**Consultation Response from KC,
Highways Development Management****2023/91530 Edgerton Villa, 22/24, Edgerton Road, Edgerton, Huddersfield, HD3 3AD****Alterations to convert offices to 7 flats (Listed Building within a Conservation Area)****Date Responded: 13/09/2023.****Responding Officer: D. Stainsby****Responding Ref: K5-5NW/12****RECOMMENDATION:**

LOWER GROUND FLOOR

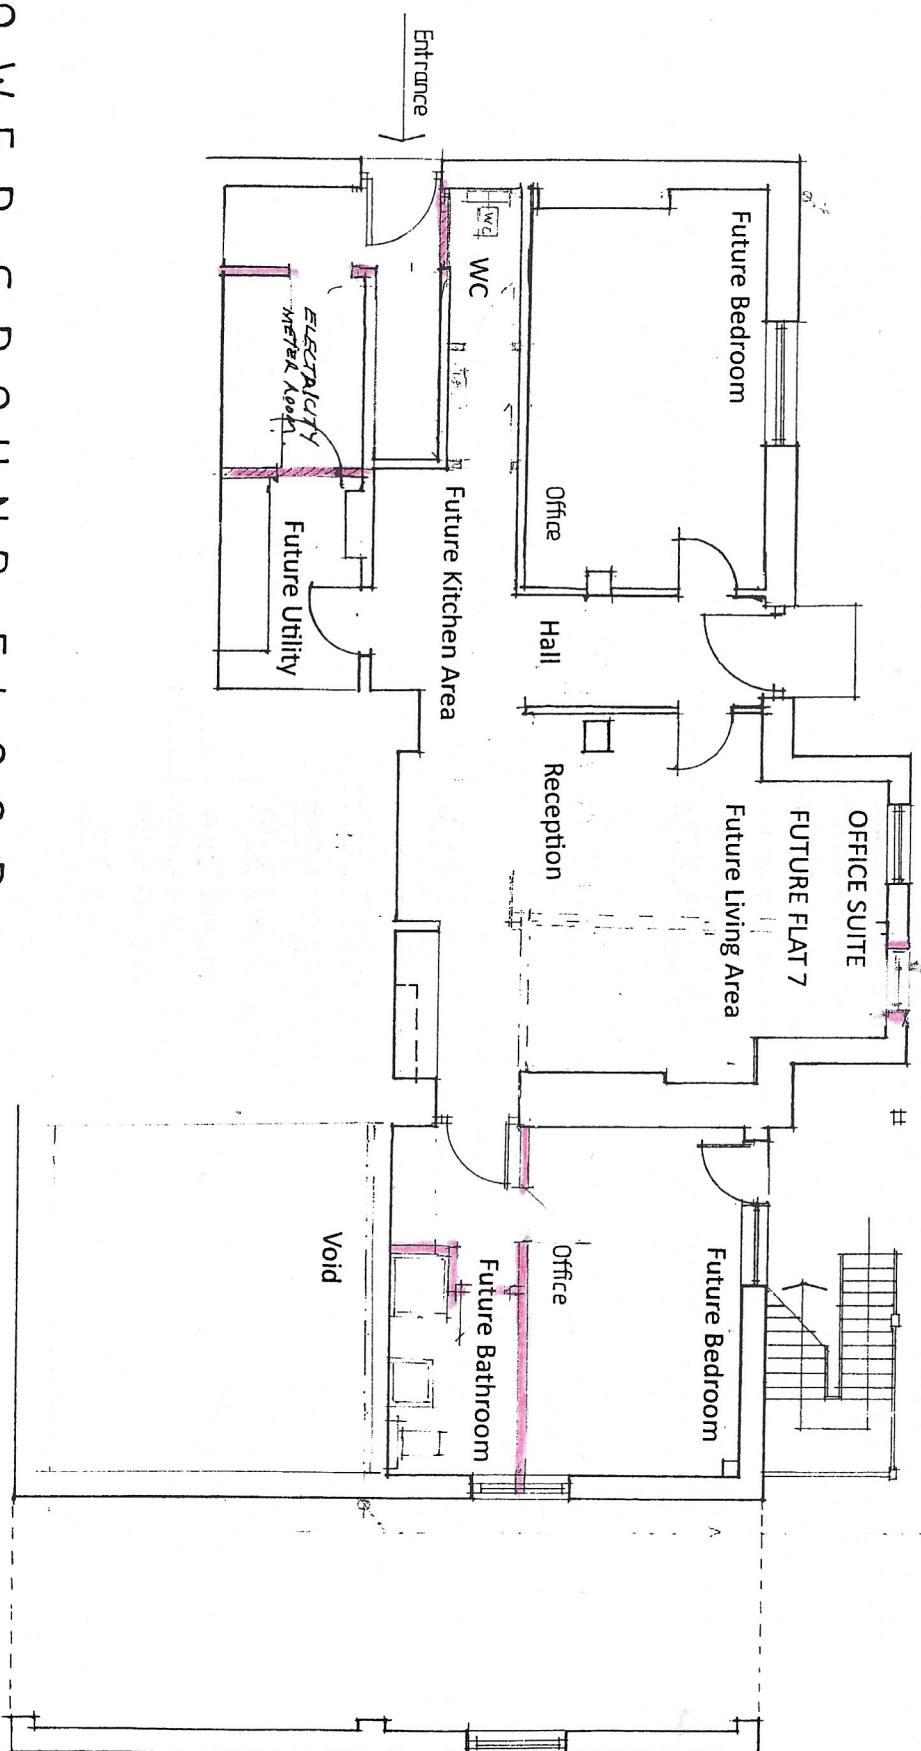
The proposal shows 19 parking spaces (two spaces per dwelling, four spaces for visitors and one space unallocated)

Whilst this provides ample car parking for the proposed development in theory, in practice the area available could not accommodate this number of vehicles.

Car parking spaces 01 to 14 are too small at 2.1m wide by 4.2m long.

Car parking spaces 15 to 19 are too small at 2.1m wide by 4.4m long.

The aisle width between the car parking spaces is too narrow at 5.2m and should be increased to a minimum of 6m wide and extended for a minimum of 1.0m past the end of spaces 01 and 15 to allow for vehicles to access these parking spaces.

Cycle parking is shown to be located in car parking spaces 13 and 14 with no further details on how they will be stored.

The proposed location of the bin storage area obstructs the pedestrian access to the site and will need to be relocated within the site whilst still being accessible by the refuse collectors.

The car parking spaces should be a minimum of 2.4m wide x 4.8m long.

A revised plan showing a minimum of nine car parking spaces is required.

A secure cycle store should be proposed that would accommodate a minimum number of seven cycles (1 cycle parking space per apartment)

A revised plan showing a secure cycle store of an adequate size to accommodate a minimum of seven cycles is required.

A revised plan showing the location of the bin store in an area which does not obstruct access to the site is required.
